**CITY OF ALBUQUERQUE
PLANNING DEPARTMENT
June 22, 2005
DRB Comments**

PROJECT # 1003629

APPLICATION # 05-01008

RE: Parksito subdivision/minor p&f plat

PROJECT NO. 04065 SHEET 1 OF 2

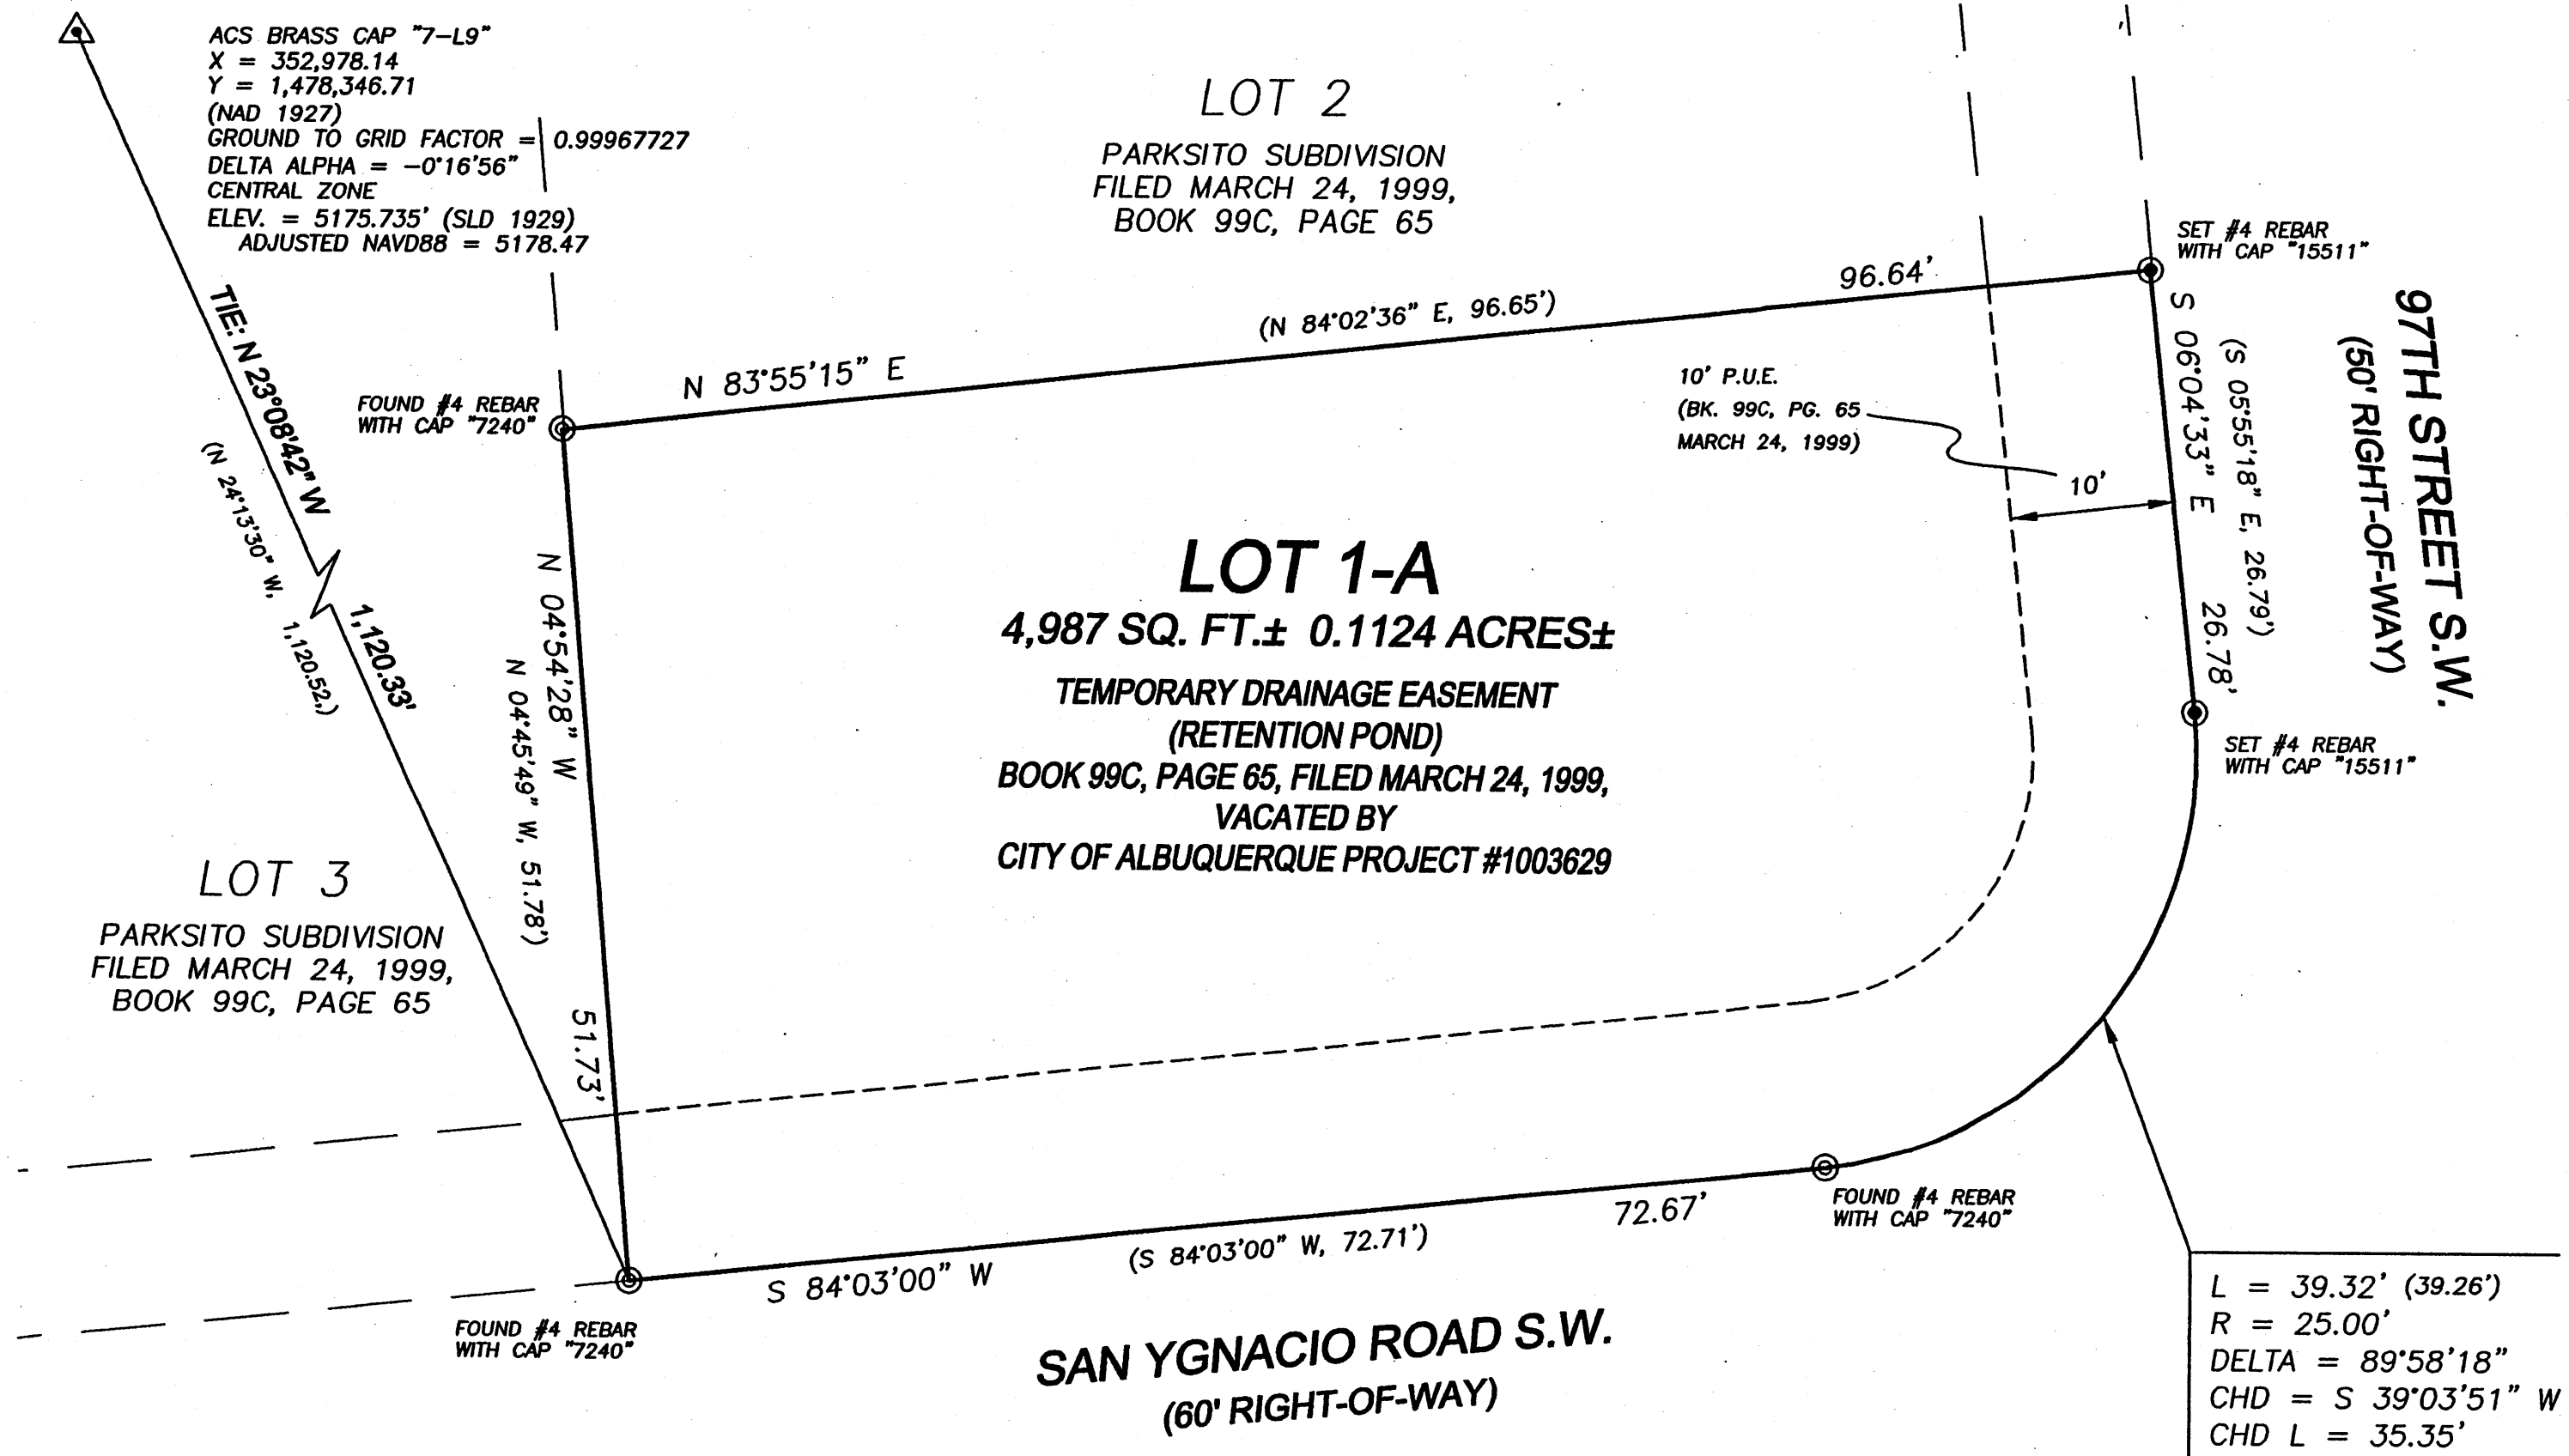
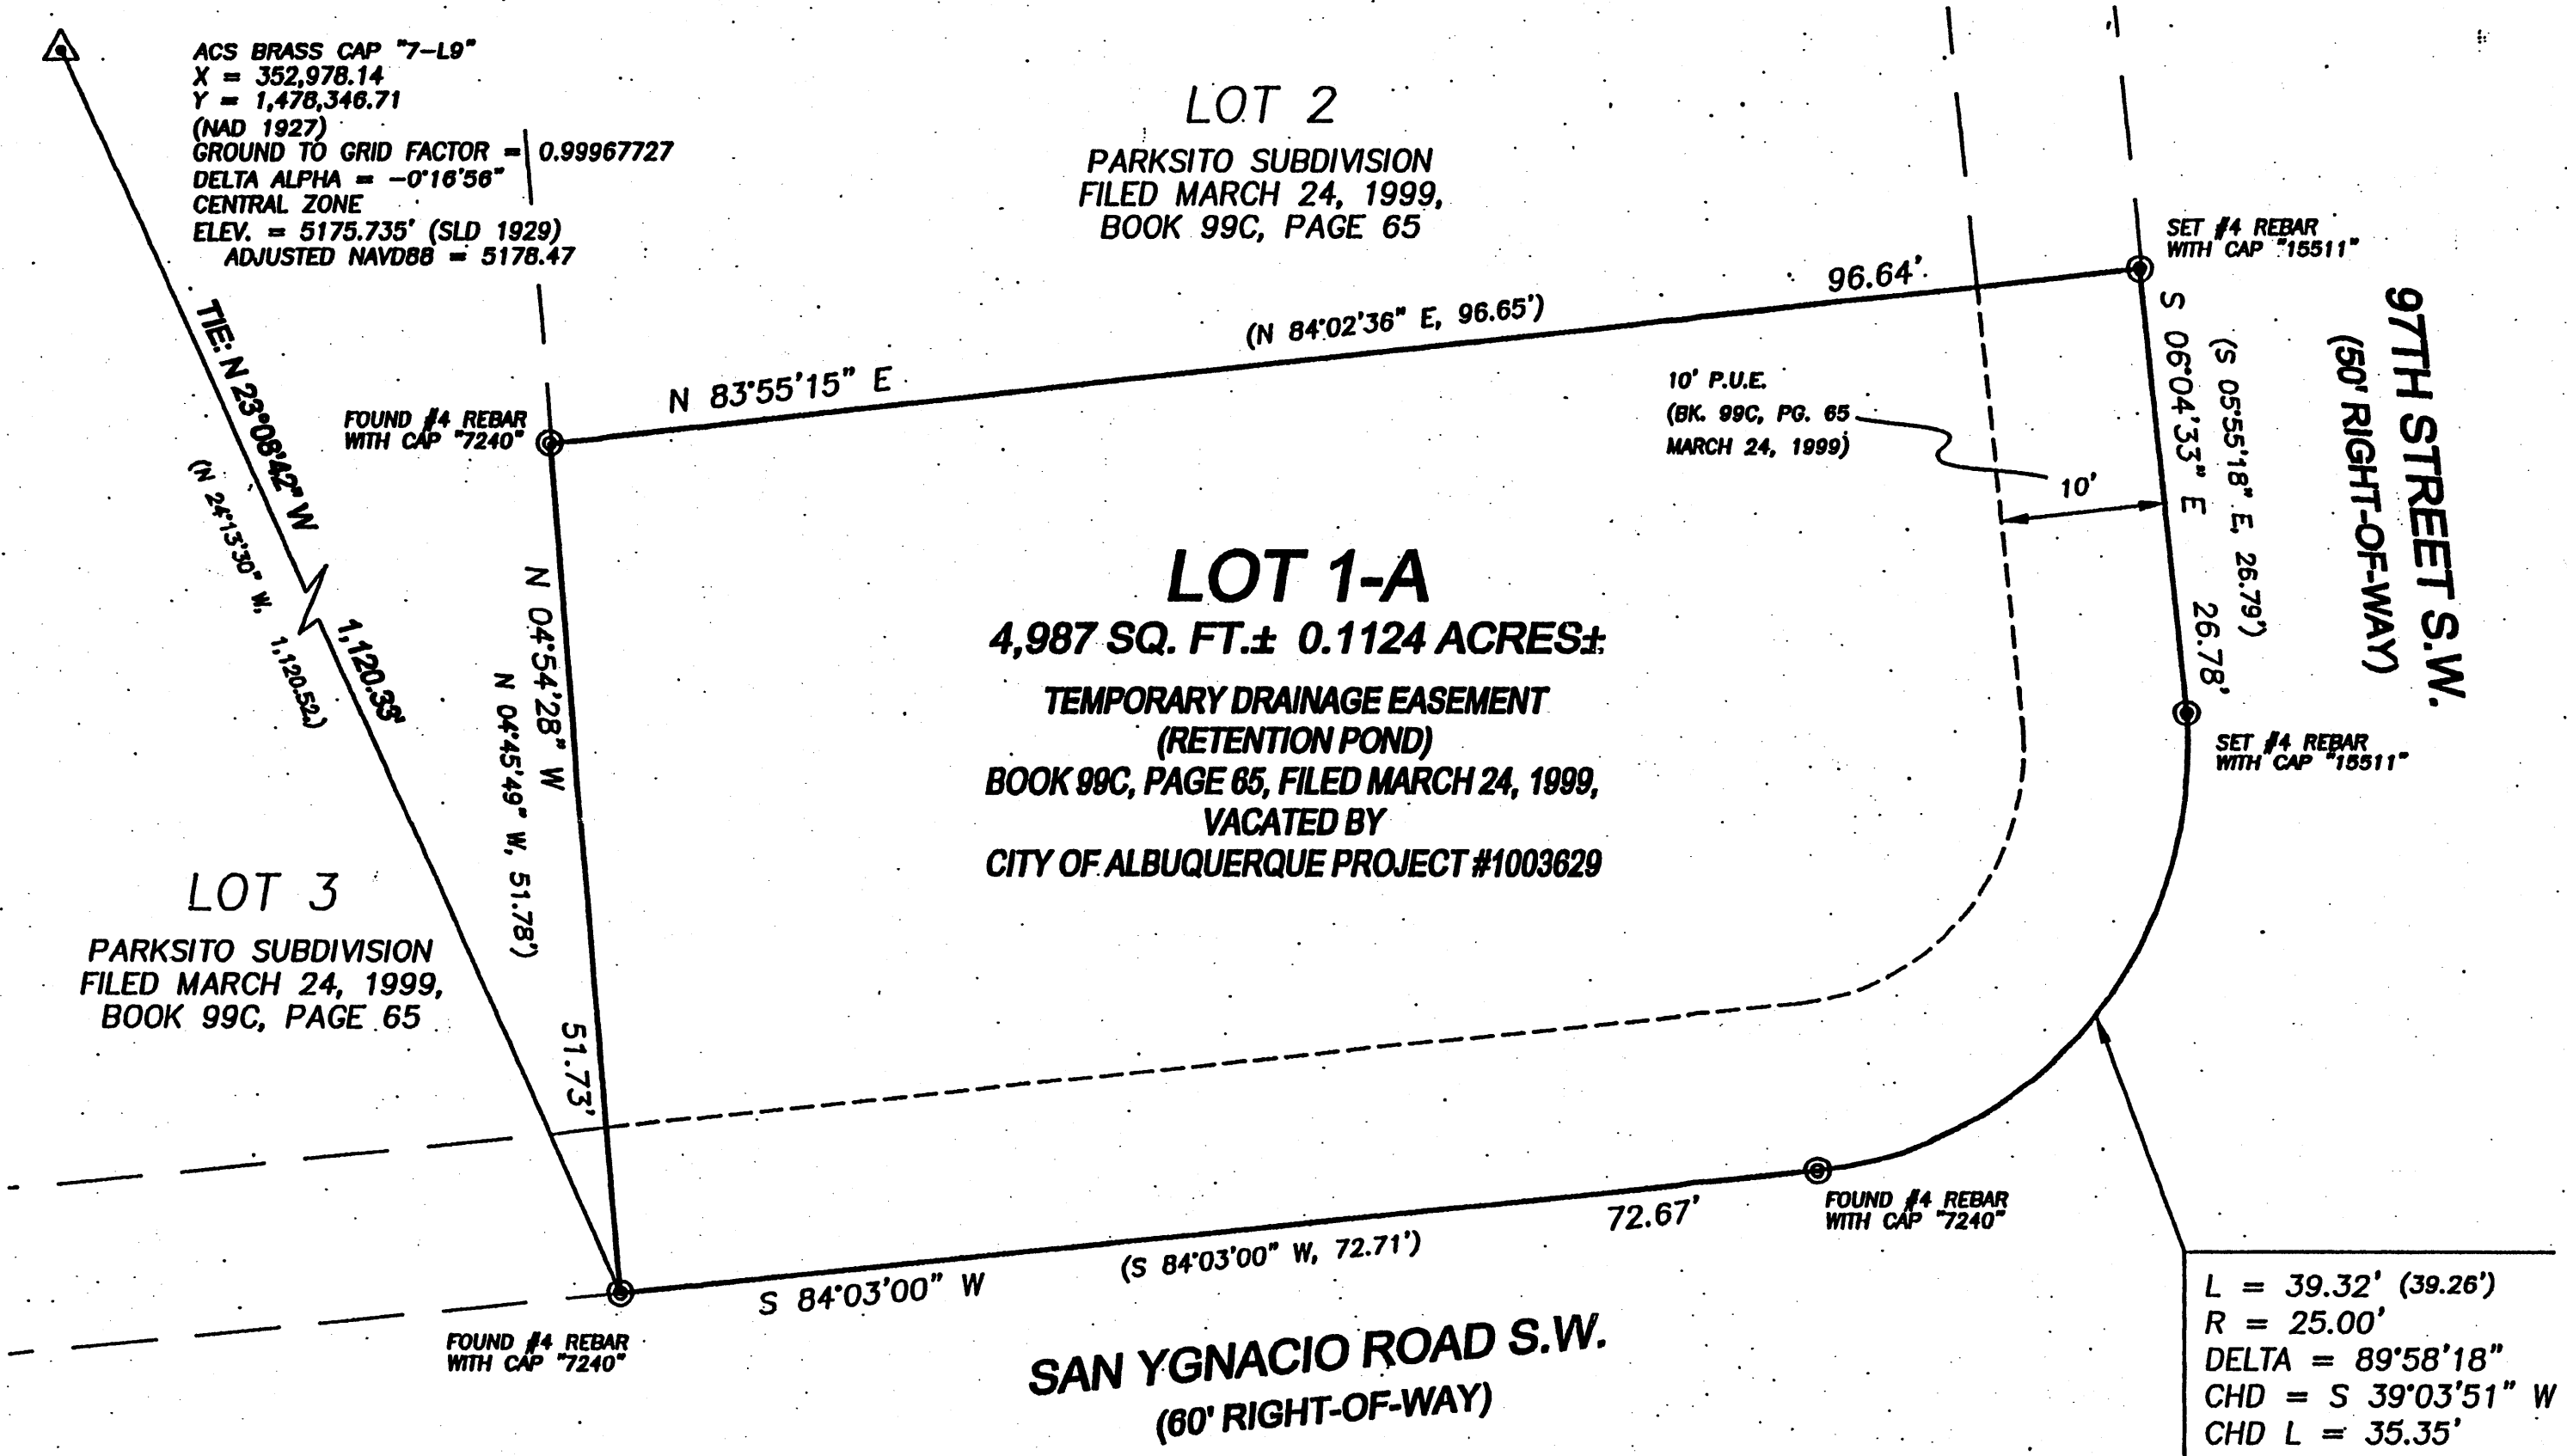
Add "complete and" before the word "indefeasible" in the Free Consent & Dedication language on the plat cover sheet.
